From: Martin Farrer [REDACTED]
Sent: 14 December [REDACTED]
To: Amber Willard
Cc: 'Clive Matthews'; 'Juliet Matthews'
Subject: RE: Gulls, 7 Second Avenue, Felpham - FP/182/20/HH
Attachments: 3249_P_01A - proposed plans.pdf; 3249_P_02A - proposed elevations.pdf; 3249_P_04 - addressing measures to prevent overlooking.pdf

FP/182/20/HH at Gulls, First Avenue.

Job No: 3249
Dwg No: P_01 A

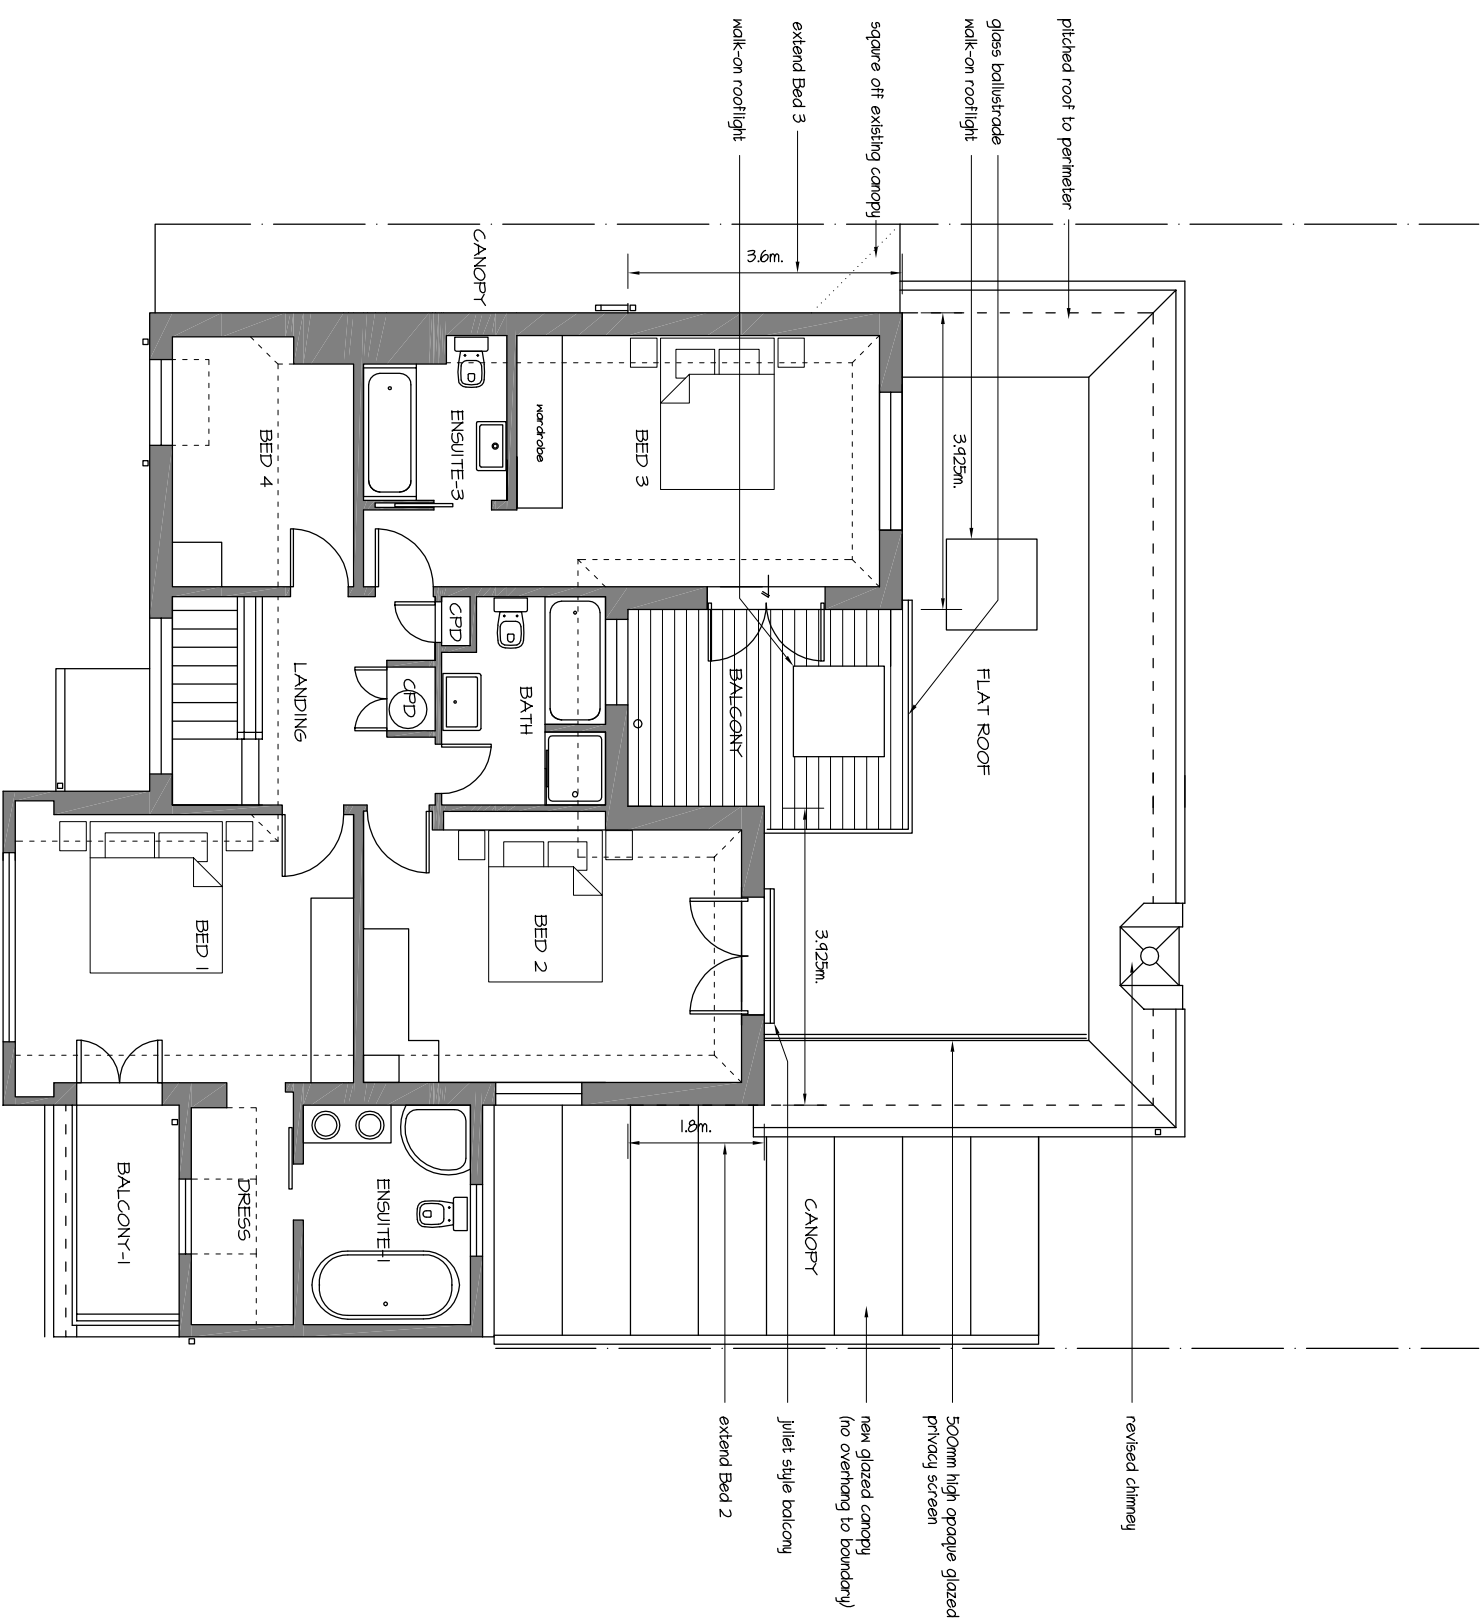
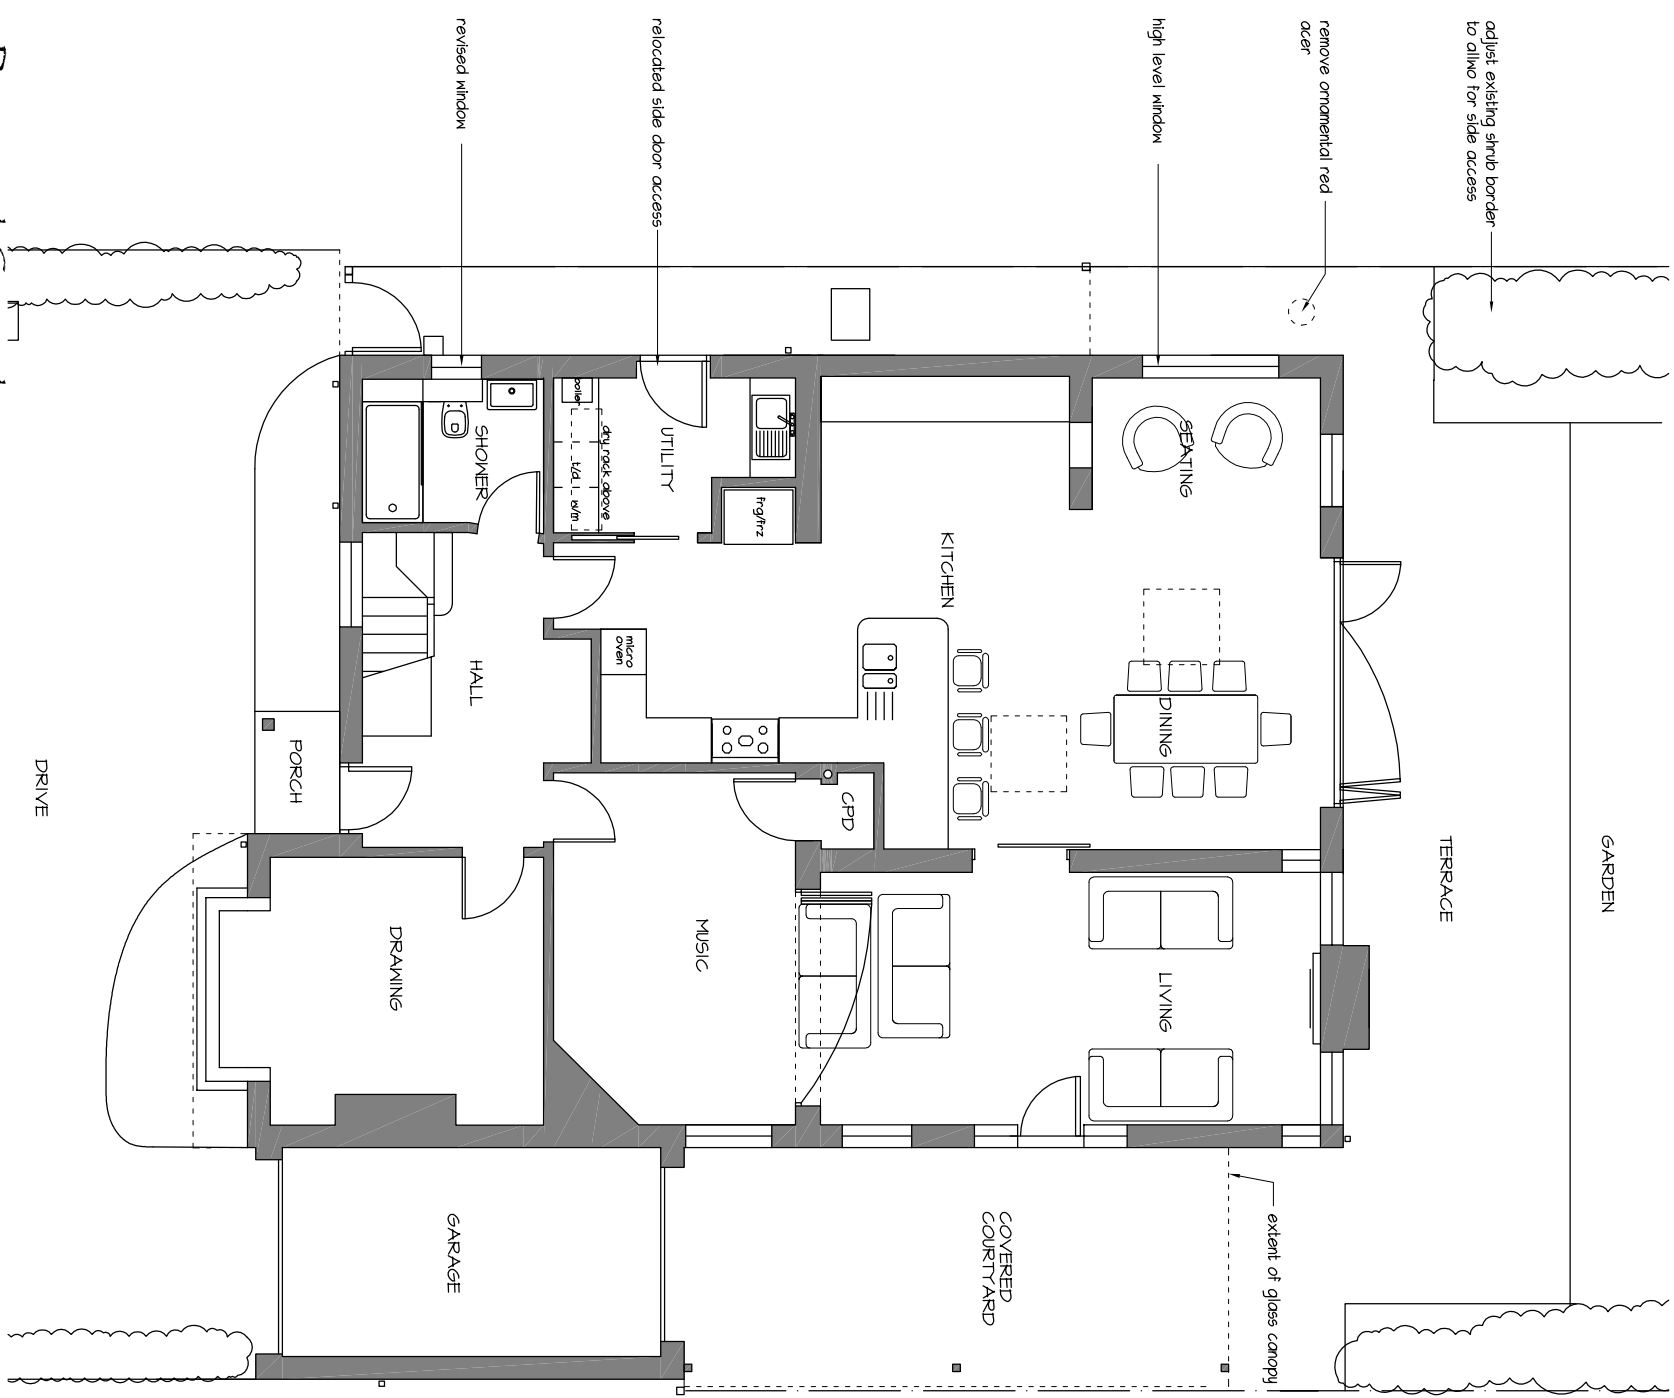
Further to our conversation earlier today, I understand you would require an obscure screen approx. 1.7m in height to the north and south balustrading in order to satisfy concerns of overlooking to neighbouring properties. I advised this would be no higher than soffit height and would also obscure views from within the bedrooms to the sea to the south.

With the view that the reduced size balcony and inclusion of the small privacy screen now addresses the concerns raised, I have also attached updated proposal plans and elevations with plans P_01A and P_02A respectively.

In order to omit any obscure screening and blockage of sea views I am suggesting reducing the size of the balcony area to contain within the centre of the flat roof area, between Bed 2 and Bed 3. This would also include a Juliet style balcony to Bed 2 with glass screen in front of the doors to prevent egress onto the flat roof. I have attached a

sketch SK_01 for clarification which shows the new balcony area coloured in purple. The glass balustrading would extend around this smaller balcony area to prevent egress onto the flat roof at 1.1m height above ffl. The balcony area would now be set back significantly from the boundary which would prevent overlooking but allow for views to the distance across to the sea.

Job No: 3249
Dwg No: P_02 A

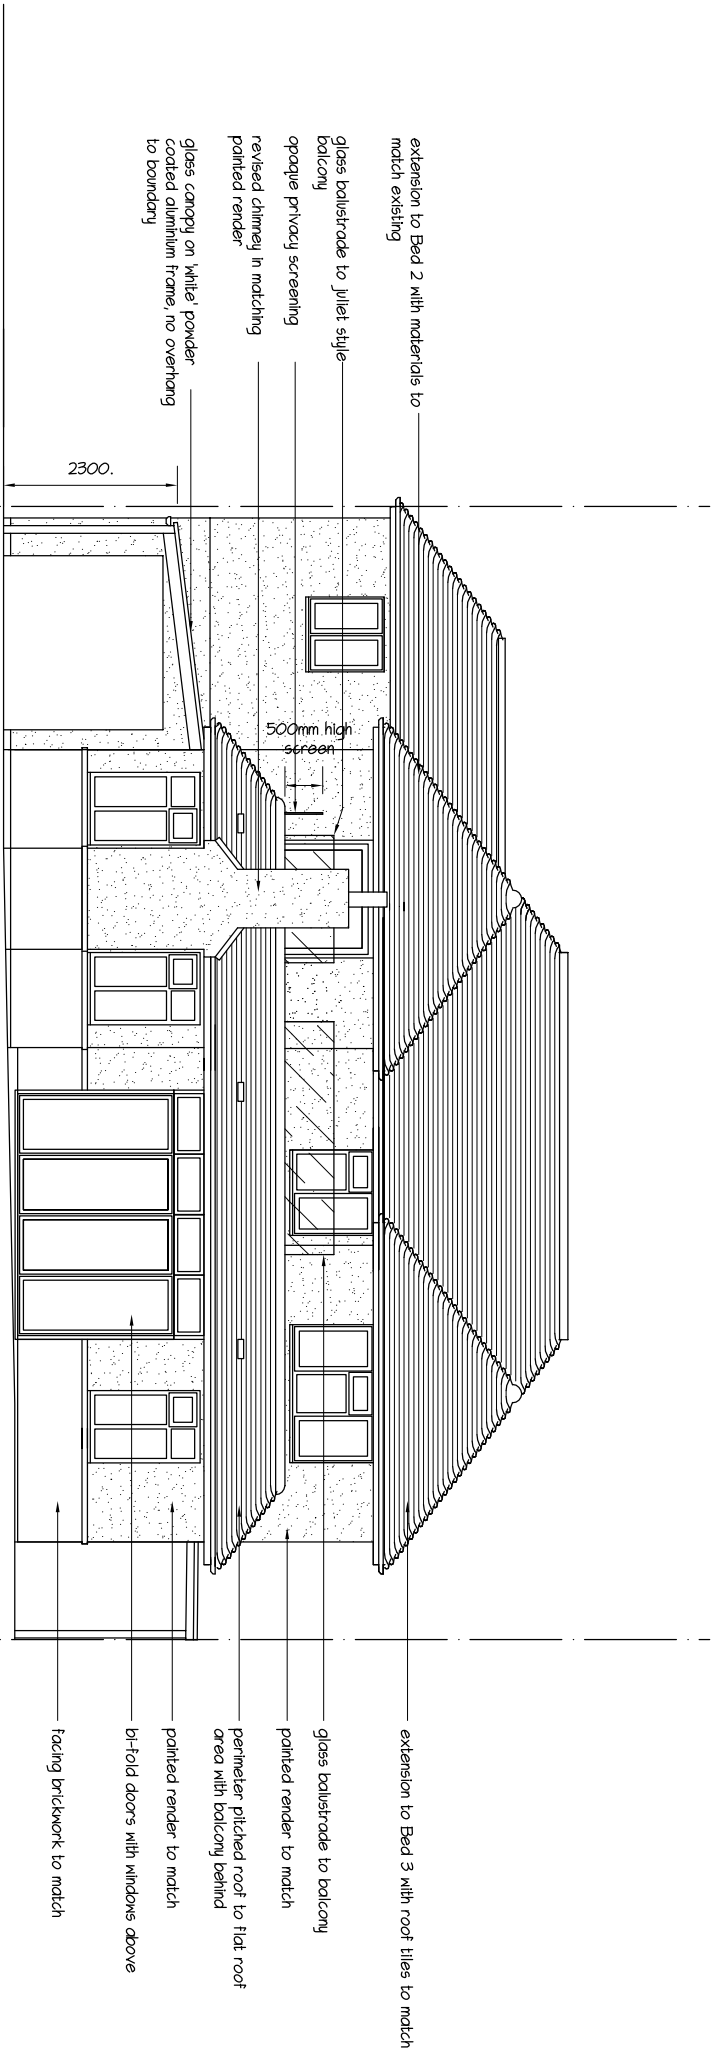
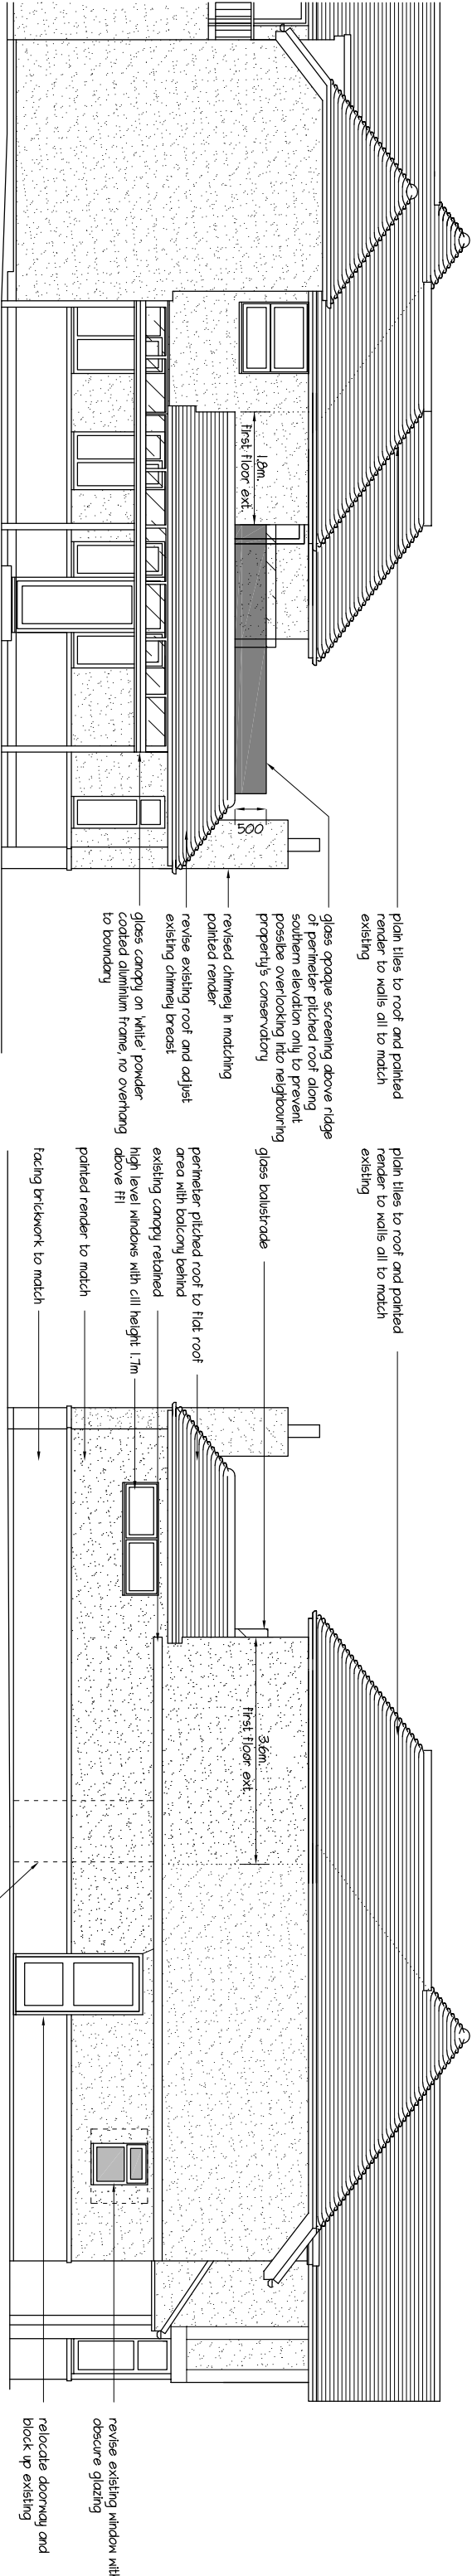
'I don't think the view from the smaller balcony would be more harmful than the adjacent window. It would be helpful if the agent could indicate on a plan a person of 1.8m height at the very corner of the new balcony and a line to show what they could view when looking to the conservatory. It might be necessary to have a small screen still on the very edge of the roof.'

This has shown that there may be a possibility of overlooking, as shown with line 'A' with the existing scheme. To address this possible concern, I have therefore suggested the addition of a small privacy screen at 500mm high along the top of the ridge to the perimeter pitched roof along the south elevation only. With this screen in place the new line of sight is shown by sight line 'B'. This indicates that the screen would prevent any possible overlooking into the conservatory, and therefore addresses the concerns raised. With the height at 500mm it also allows for views above and into the distance towards the sea for the applicants.
